RE: ENGINEER CERTIFICATION FOR TAYLOR RIDGE APARTMENTS PHASE I & II
(E12-D9) CERTIFICATION STATEMENT DATED 9/25/97

RE: DRAINAGE REPORT FOR TAYLOR RIDGE APARTMENTS (E-12/D9)
RECEIVED JANUARY 24, 1996 FOR BUILDING PERMIT
ENGINEER'S STAMP DATED 1/23/96

**RE: DRAINAGE REPORT FOR TAYLOR RIDGE APARTMENTS (E-12/D9)
RECEIVED AUGUST 15, 1995 FOR GRADING & BUILDING PERMIT
ENGINEER'S STAMP DATED 8-14-95**

GRADING & DRAINAGE PLAN

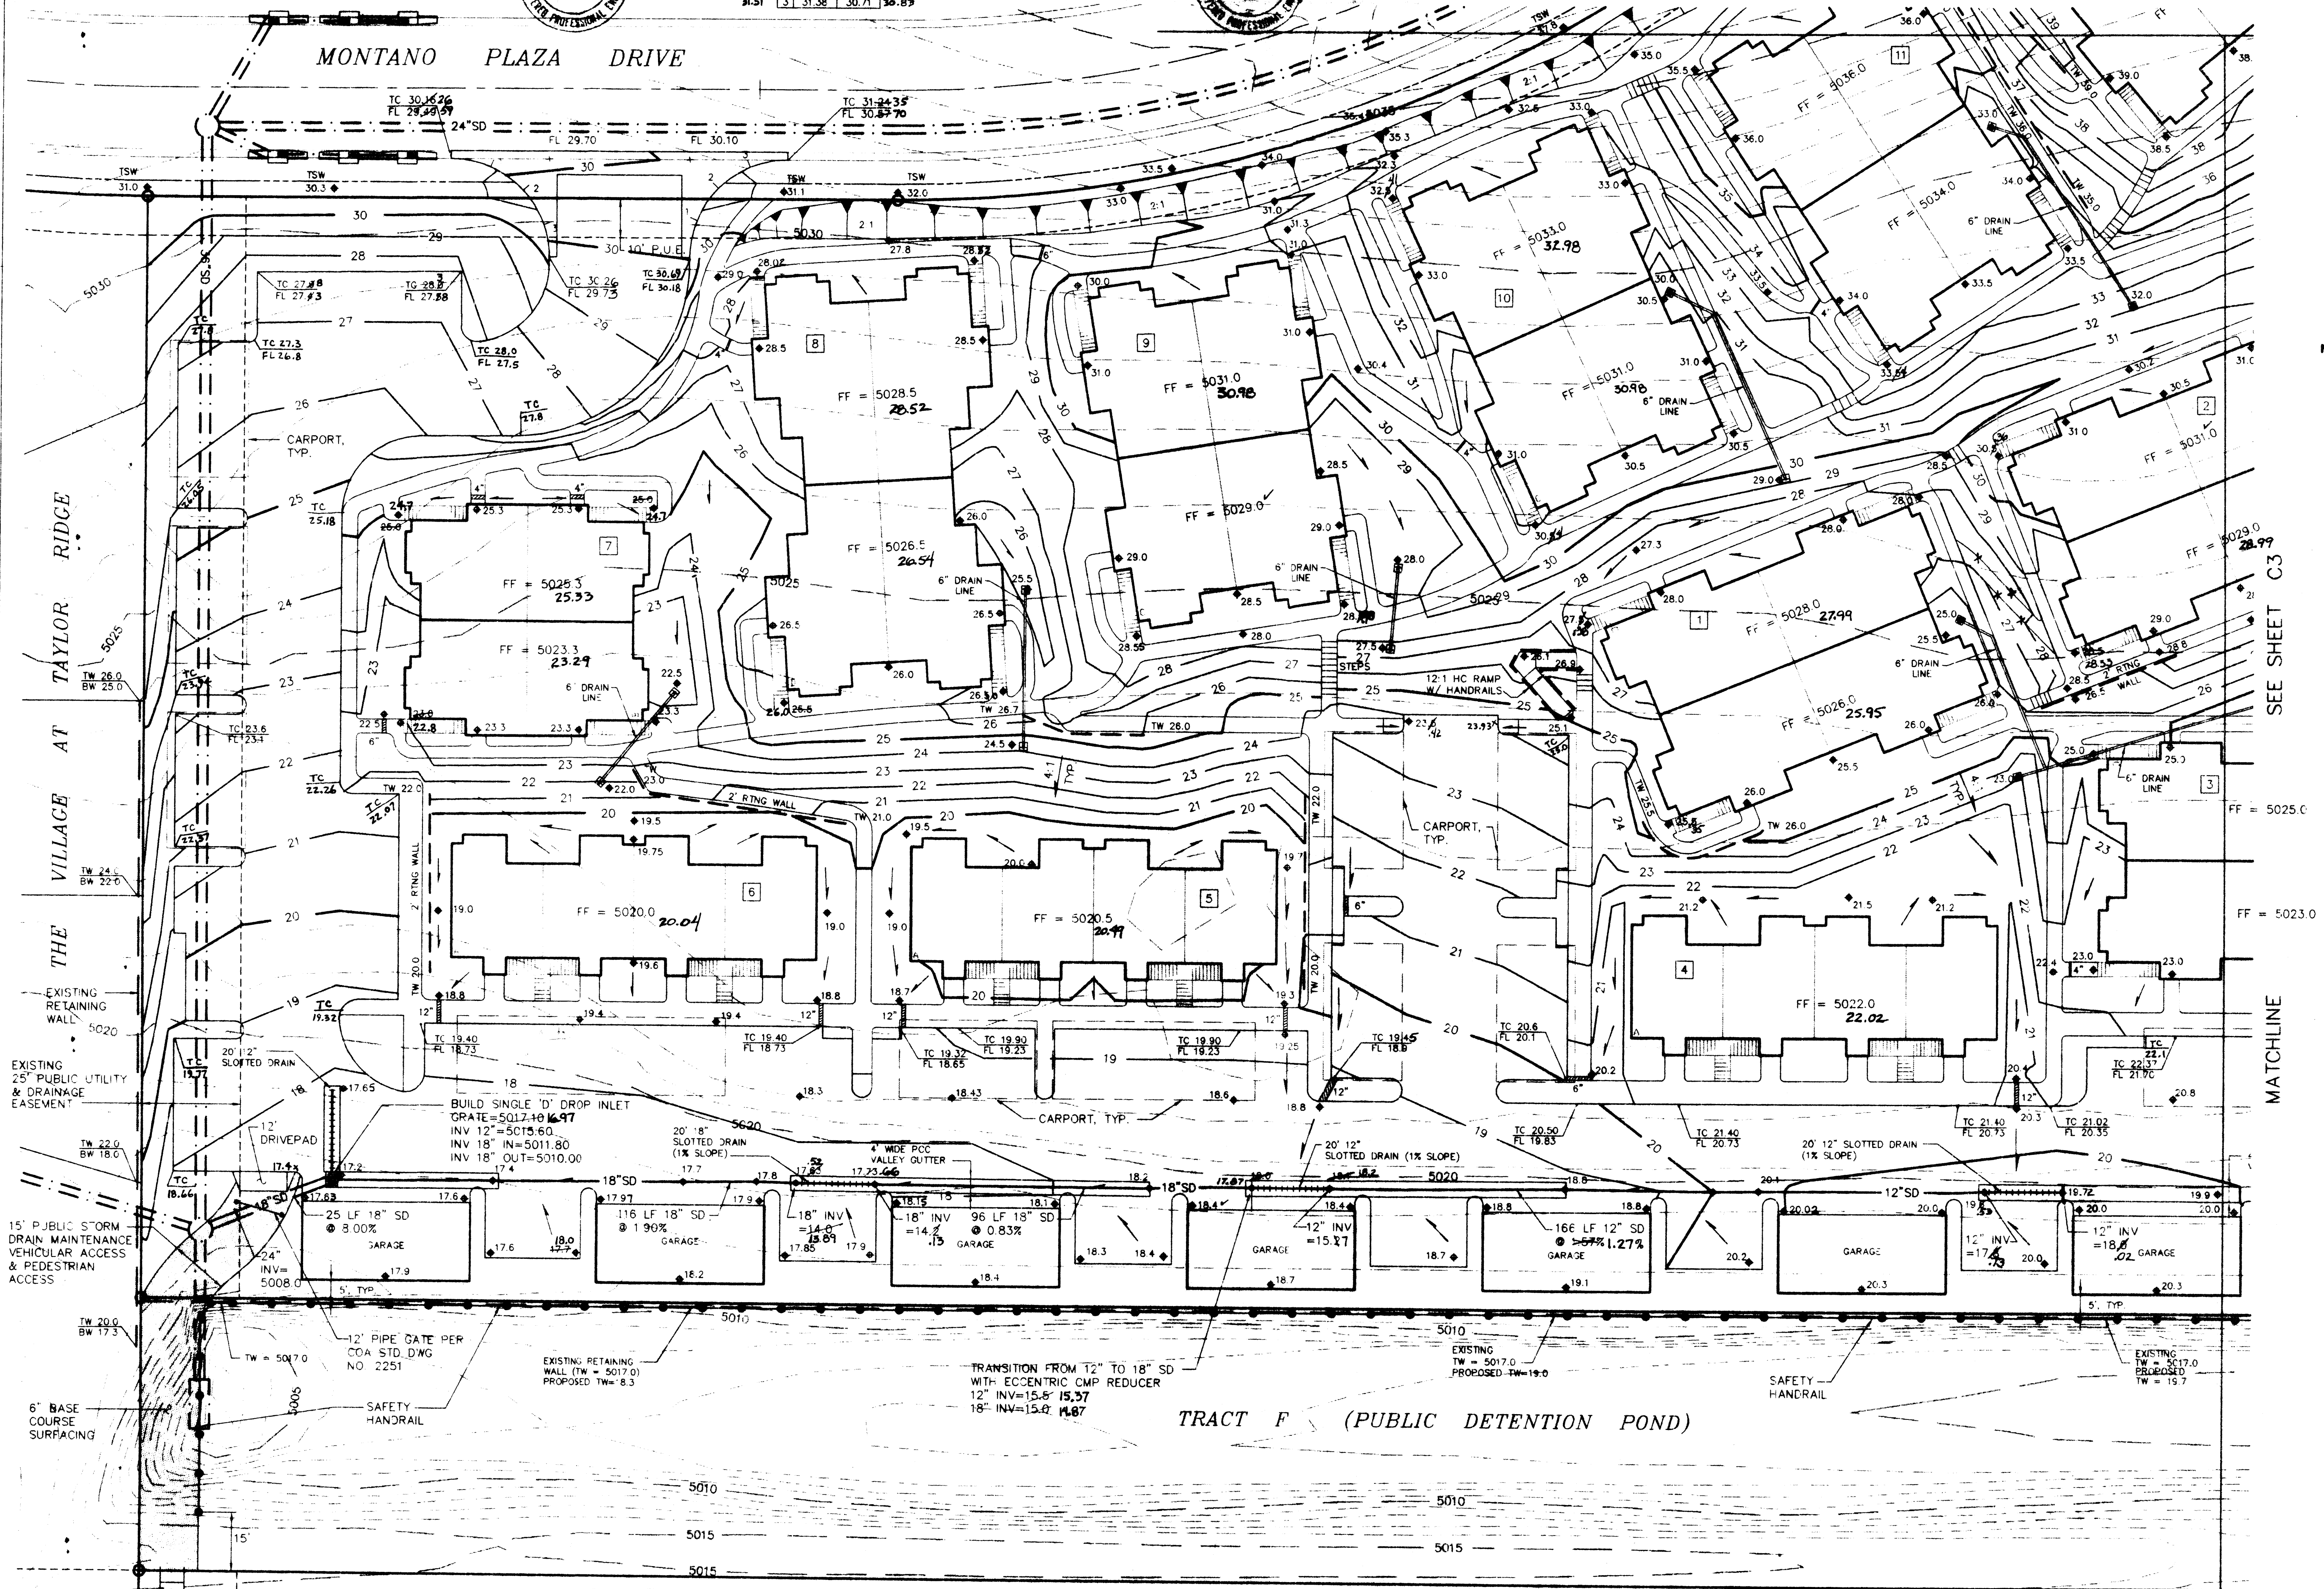
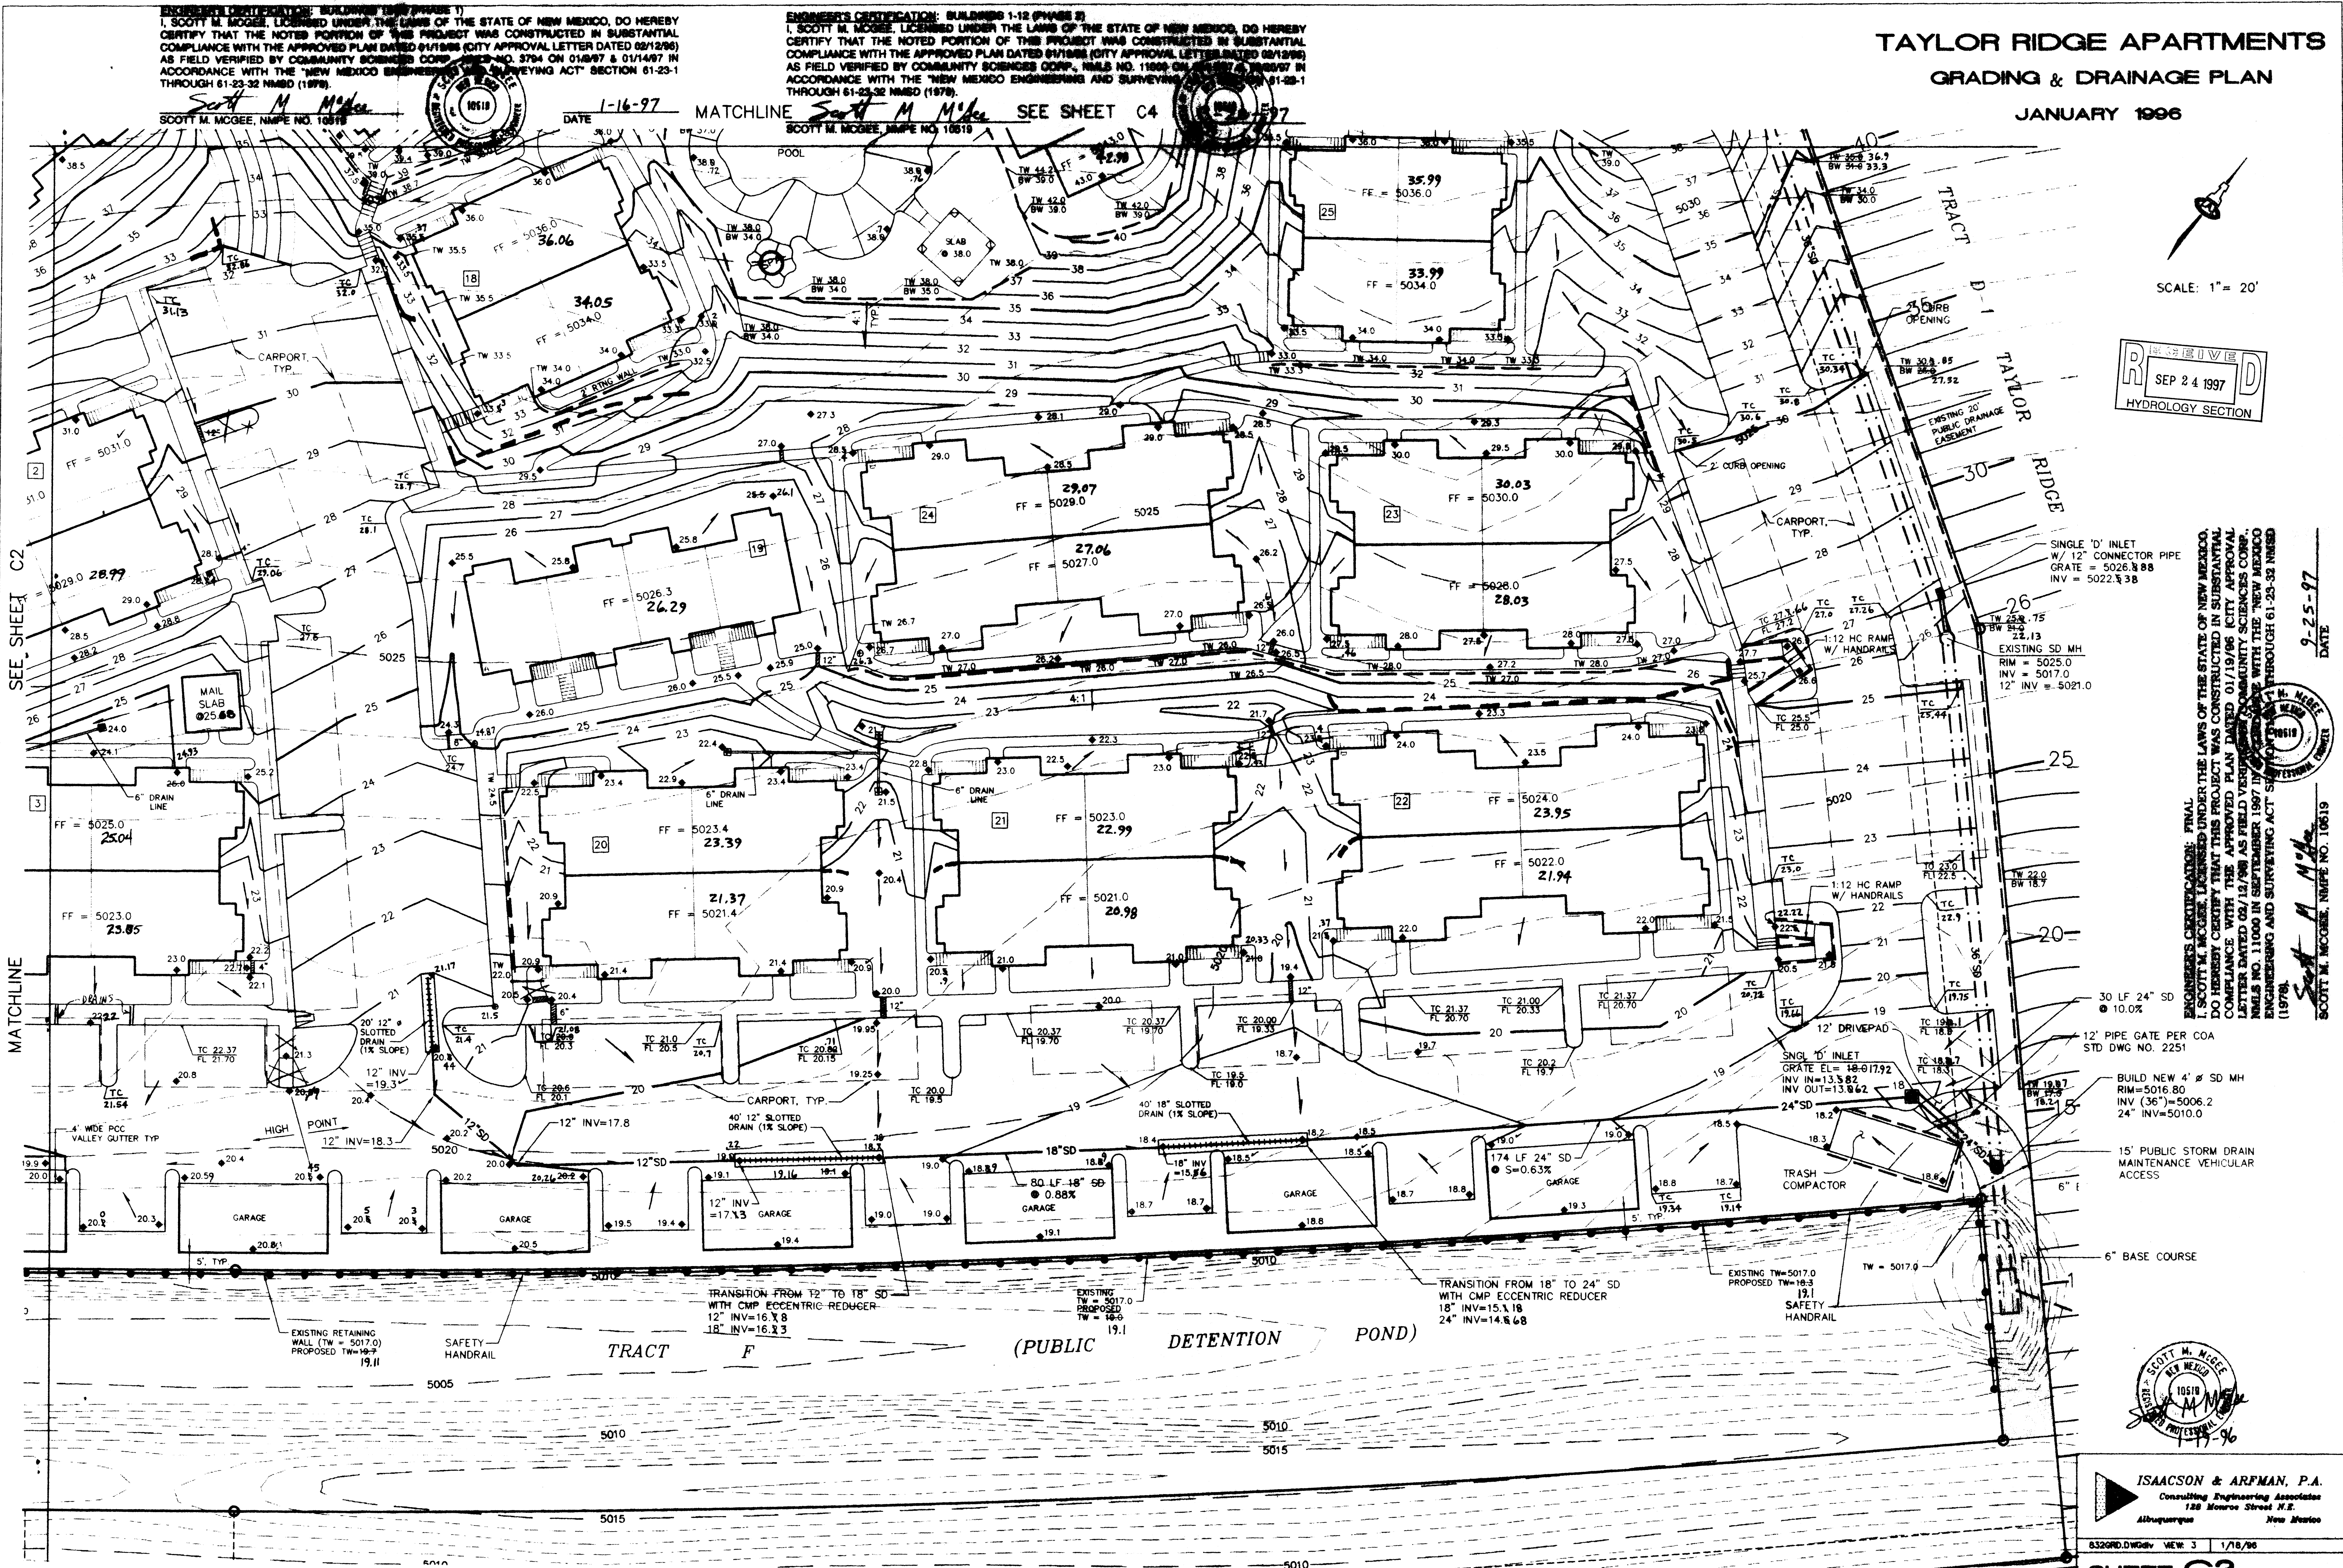
Engineer's Certification of grading & drainage per DPM checklist must be accepted by City Hydrology before any Certificate of Occupancy will be released. Certification must verify that there is at least a .87' water block at each entrance.

Provide sufficient spot elevations at each entrance to verify the water block. The private storm drain needs inverts and a detail for the slotted drain. Label the Fire Access on Sheet C4. Check with Glenn Jurgensen to see what sort of access easement he will need to reach the detention pond. Any slopes steeper than 3H:1V require a gravel mulch per C.O.A. Spec Sect 1012.

Provide a final design for the private storm drain. Indicate how much each inlet intercepts and the slope and flow through each pipe. Calculate the hydraulic grade line. Check the existing storm drain for the additional flow proposed.
